Urban Design Observations			Officer:	Stephen Kilmartin
Description:	Land off Waddington Road, Clitheroe			 Ribble Valley Borough Council www.ribblevalley.gov.uk
Application Ref:	2018/0181	Case Officer:	S.K	
Response Ref:	2018/0181/UD/02	Issue Date:	07/11/18

General Observations:	
1.1	The following observations are in relation to Preliminary layout drawing DWH063 – PL01 Rev: P3 received on the 2 nd of November 2018.

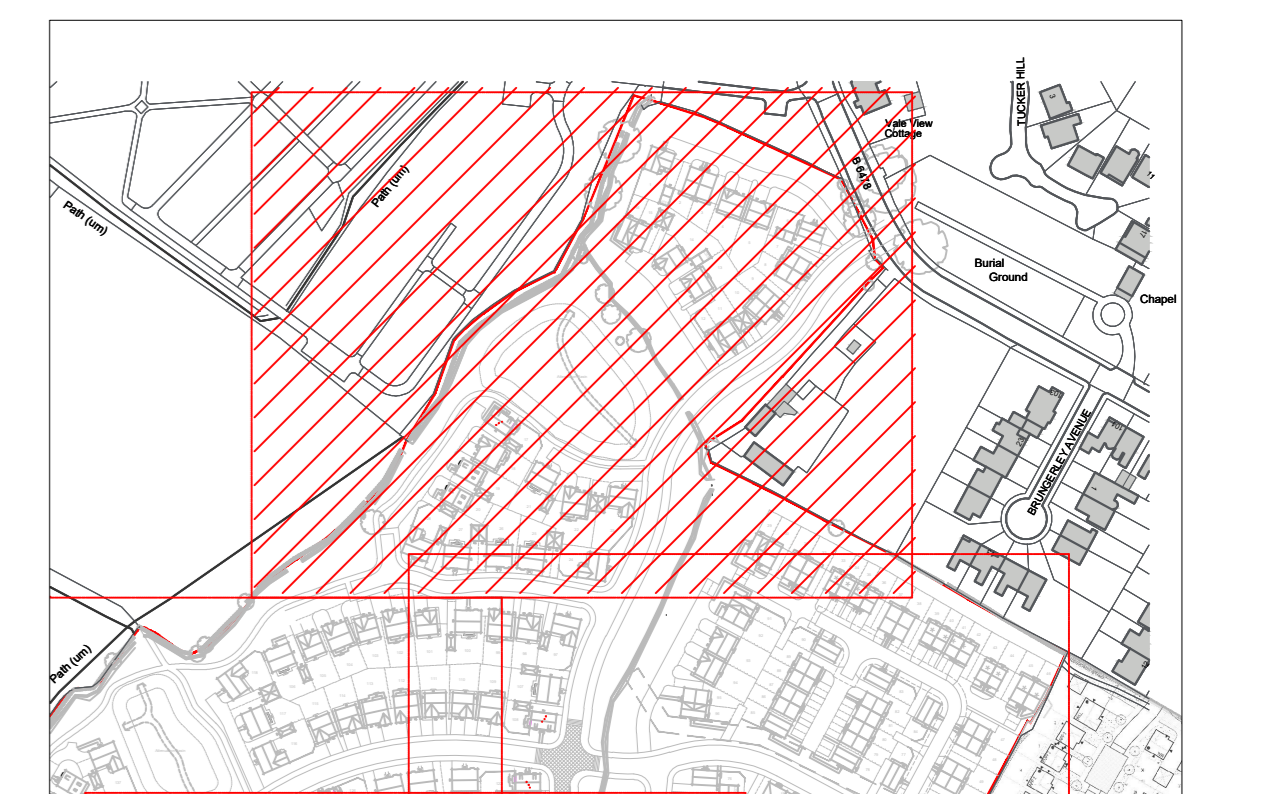
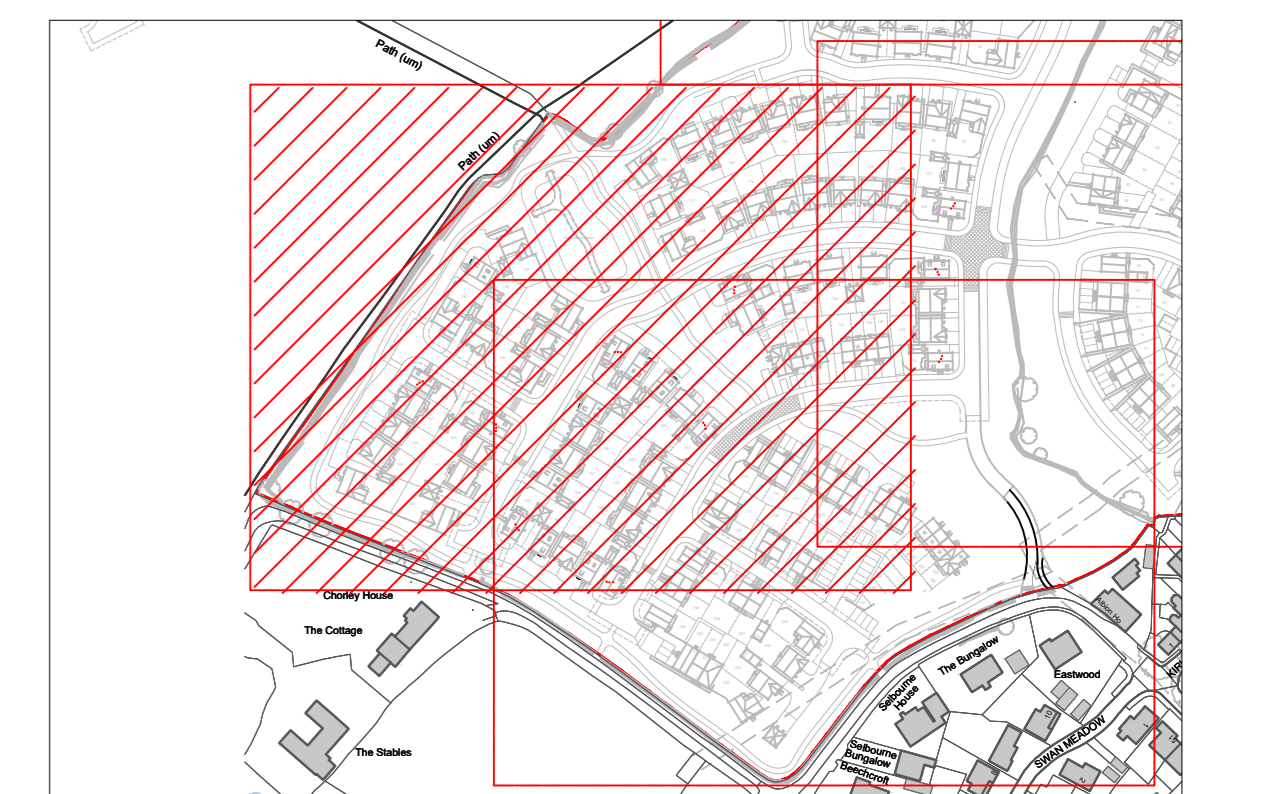
- 3.2** As no detailed landscaping proposals have been presented at this stage I am unable to offer any observations in relation to these matters.
- 3.3** There are a number of 'green' areas within the public realm that do not appear to be 'on-plot' I would expect such areas to accommodate significant tree/shrub and hedgerow planting to contribute to the overall ecological/biodiversity enhancement of the site.

- 3.4** I note the inclusion of the 10m buffer around the periphery of the development site. A full planting schedule will be required in respect of the proposed landscaping of this margin. I would expect such a schedule to include a significant amount of native species tree and hedgerow/shrub planting.

- 3.5** I note that the submitted sketch layout does not appear to provide any dedicated provision for usable open space. You will note that providing such provision is a requirement not only of the outline consent but also a requirement of Policy DMB4 of the Adopted Core Strategy.

- 3.6** I am disappointed that the peripheral circular pedestrian route (within the green margin) appears to have been omitted from the proposal. I would consider that this should be reintroduced to allow for opportunities for residents and the wider community to engage with the green infrastructure to be brought forward as part of the proposal. Please refer to my previous observations in relation to arrangements/points of connection.

- 3.8** The large expanses of parking areas to the south western extents of the site (plots 178-188 and plots 201-209) should be further broken up with additional tree planting to plot frontages or within the public-realm. A similar approach should be taken to plots 33-36 and 39-42.

- 3.9** The green margin to the north of plot 90 offers an opportunity for significant amenity landscaping.
- 3.10** Tree planting should be introduced into the public realm within the courtyard area serving plots 84-96.
